Our Ref: RDC 10M1837 SYD10/00681
Contact: James Hall (RN) T 8849 2047
Your Ref: MP09_0200

**SYDNEY OPERA HOUSE UNDERGROUND LOADING DOCK CONSTRUCTION
ENVIRONMENTAL ASSESSMENT
2 MACQUARIE STREET, SYDNEY**

Reference is made to the Department of Planning's correspondence dated 16 August 2010 regarding the subject Environmental Assessment (EA) forwarded to the Roads and Traffic Authority (RTA) for comment.

The RTA has reviewed the subject EA and provides the following comments to the Department of Planning for its consideration in the determination of the application:

**SYDNEY OPERA HOUSE - VAPS PROJECT  
ENVIRONMENTAL ASSESSMENT  
GROUND (LEVEL +012\')**  
EA-140 / REV.00  
0934 2 JUNE 2010

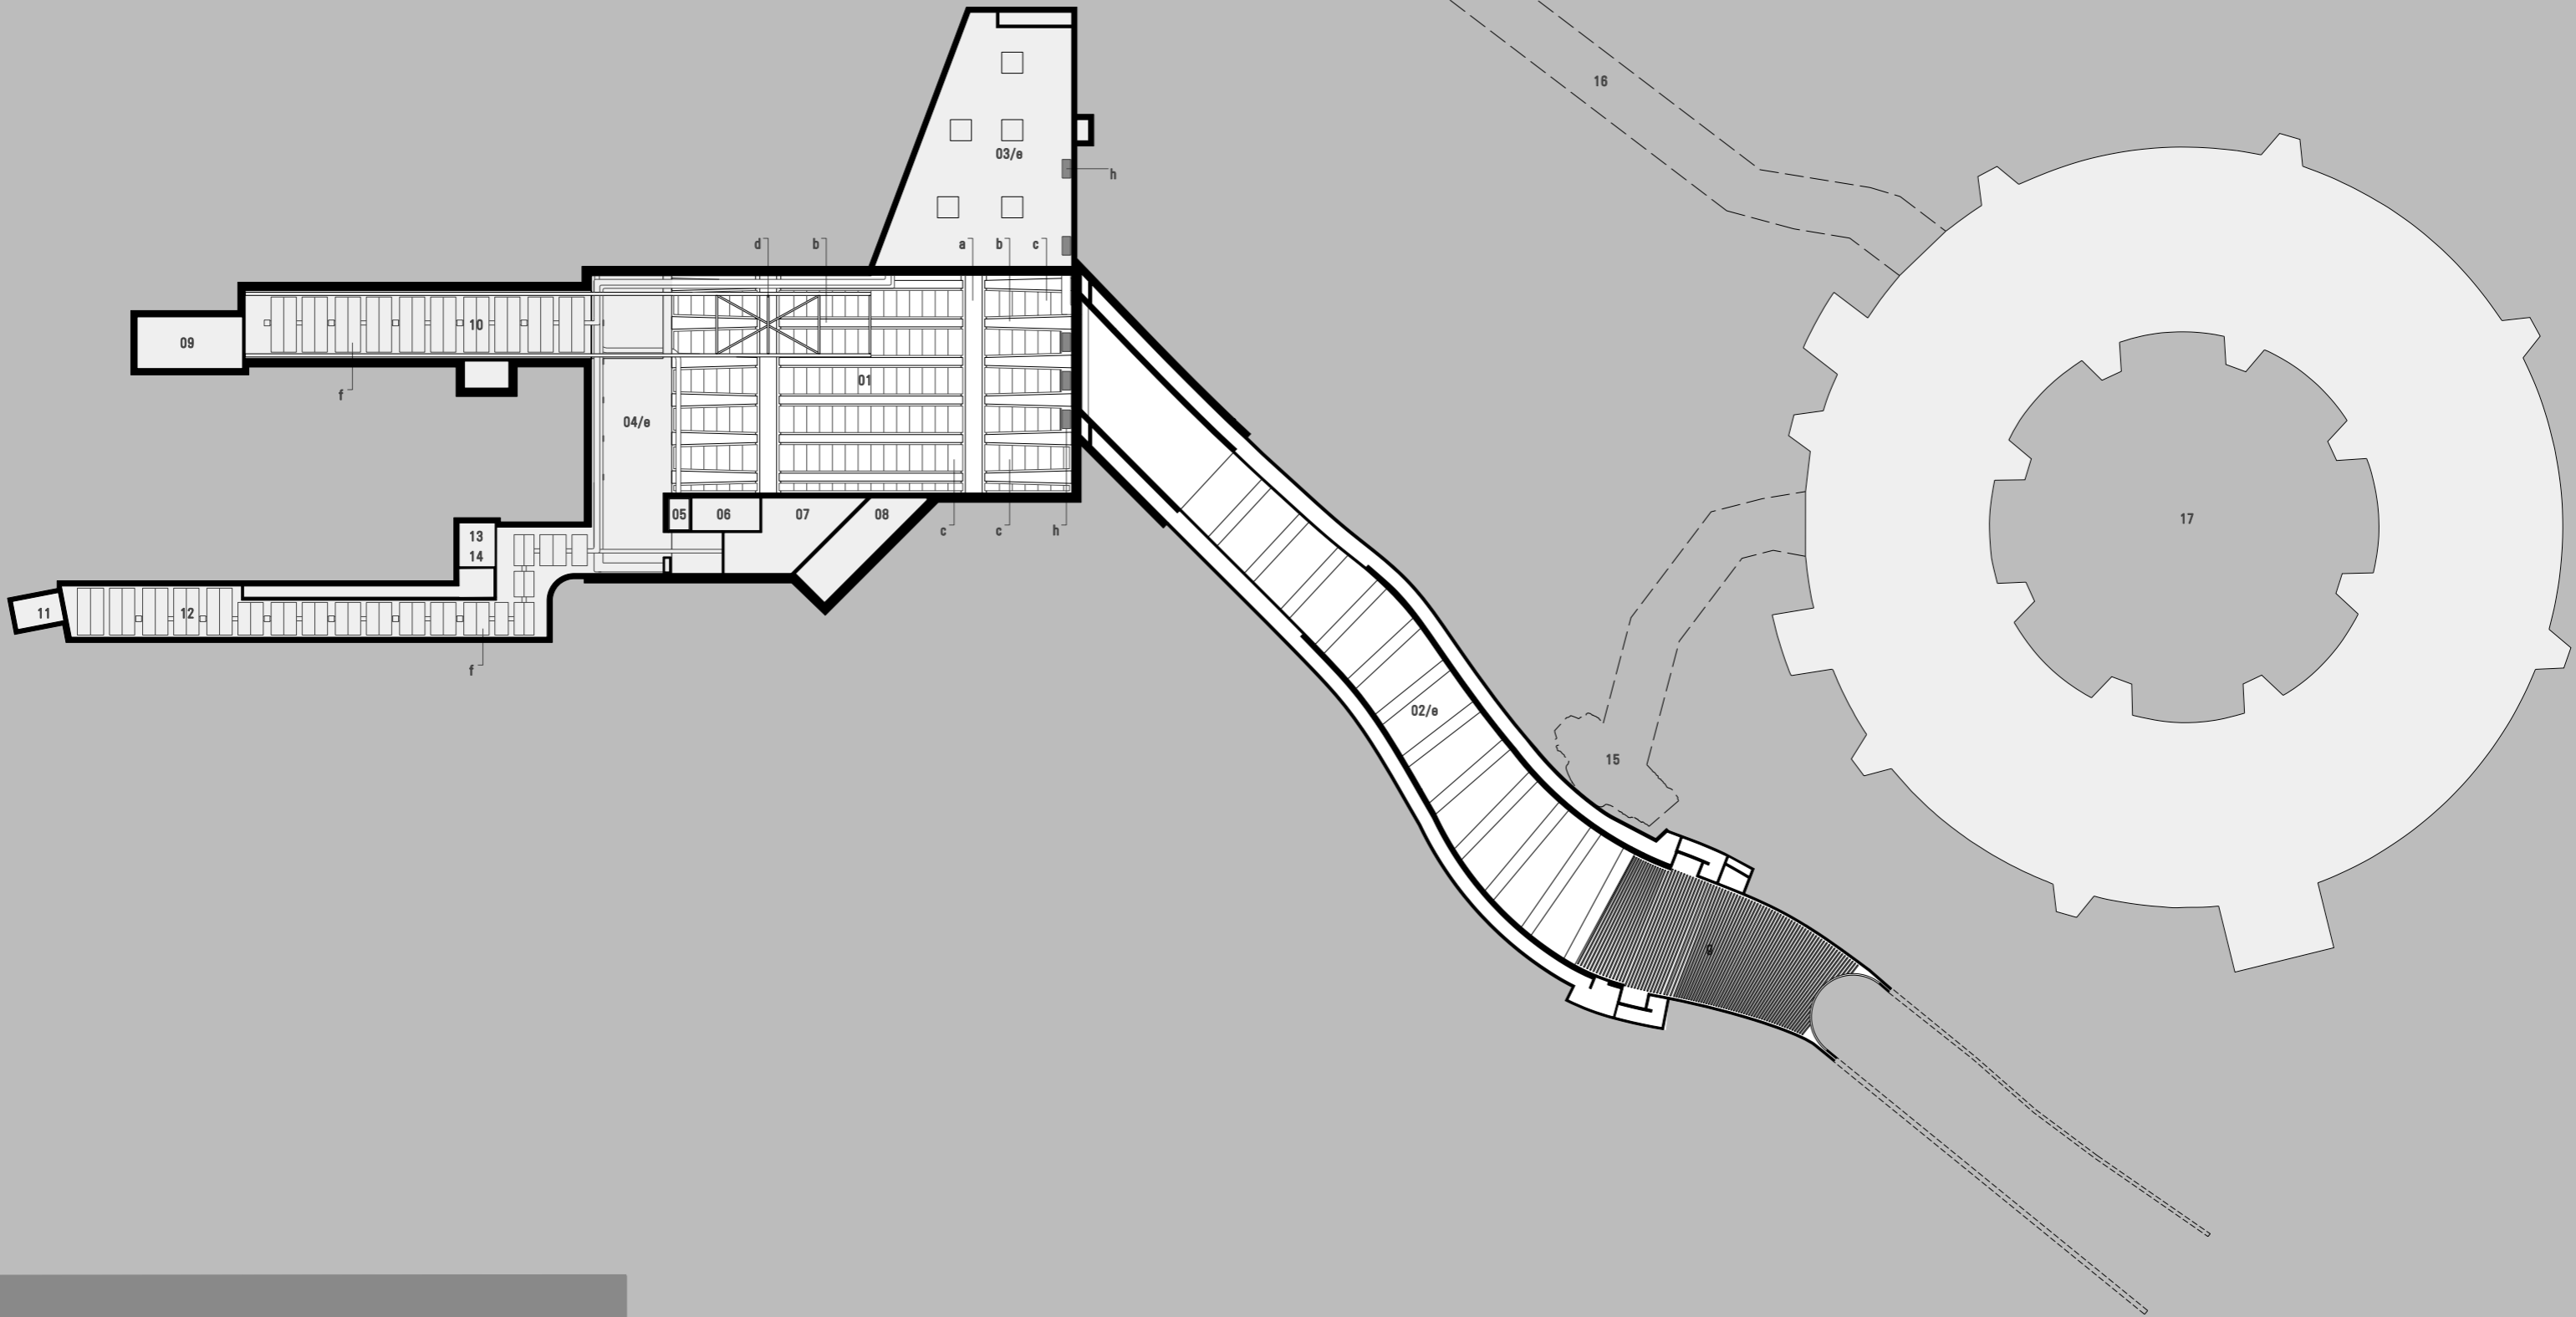
1. The layout of the proposed vehicle accessible areas associated with the subject development (including, driveways, grades, turn paths, sight distance requirements, aisle widths, aisle lengths, and parking bay dimensions) should be in accordance with AS 2890.2 – 2002 for heavy vehicle usage.

2. The swept path of the longest vehicle entering and exiting the subject site, as well as manoeuvrability through the site, shall be in accordance with AUSTROADS. In this regard, a swept path plan shall be submitted to the Department of Planning for approval, which illustrates that the proposed development complies with this requirement.

3. The proposed turning areas within the loading dock are to be kept clear of any obstacles, including parked vehicles, at all times.
4. All vehicles are to enter and leave the site in a forward direction.
